September 13, 2022

Job	Truss	Truss Type	Qty	Ply	114 BIRCHWOOD GROVE - ROOF	154135131
29556-29556A	A1AR	ROOF TRUSS	5	1	Job Reference (optional)

| Job 237_2723_A | Truss A1A | Truss Type ROOF TRUSS | Qty 5 | Ply 1 | KB Home 237.2723.A Rev Job Reference (optional) | 149418571 |

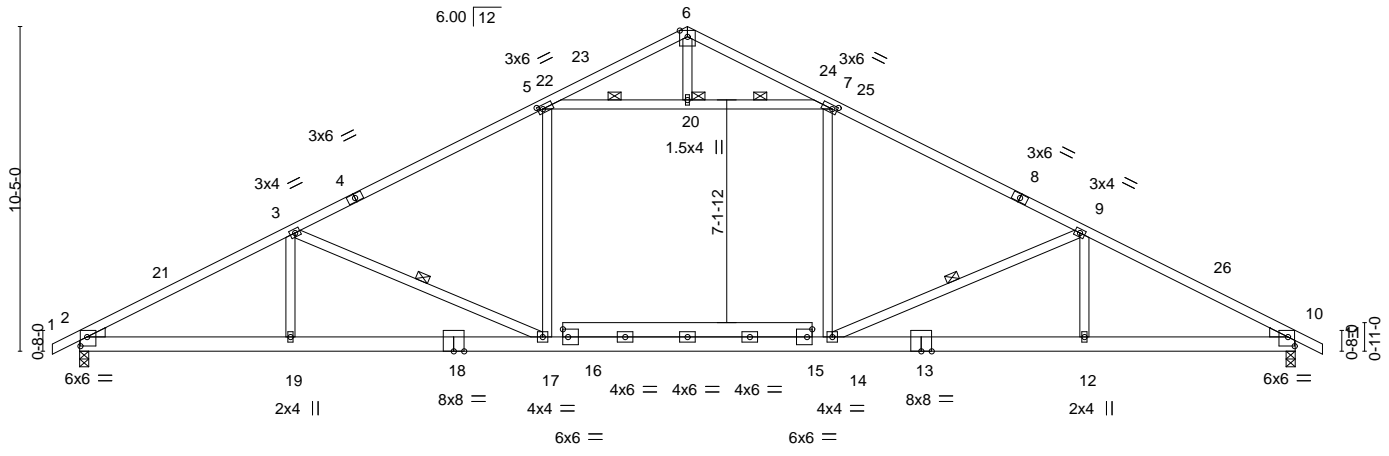
- NOTES-**
- 1) Repair Condition: Missing or damaged plate(s) on one side(s) of truss at joint(s) 14. Repair Condition: Missing or damaged plate(s) on both side(s) of truss at joint(s) 13.

ATTACH 1/2" PLYWOOD OR OSB GUSSET (15/32" RATED SHEATHING 32/16 EXP 1) TO EACH FACE OF TRUSS WITH (0.131" X 2.5" MIN.) NAILS PER THE FOLLOWING NAIL SCHEDULE: 2 X 3'S - 2 ROWS, 2 X 4'S - 3 ROWS, 2 X 6'S AND LARGER - 4 ROWS: SPACED @ 4" O.C. NAILS TO BE DRIVEN FROM BOTH FACES. STAGGER SPACING FROM FRONT TO BACK FACE FOR A NET 2" O.C. SPACING IN EACH COVERED TRUSS MEMBER. USE 2" MEMBER END DISTANCE.
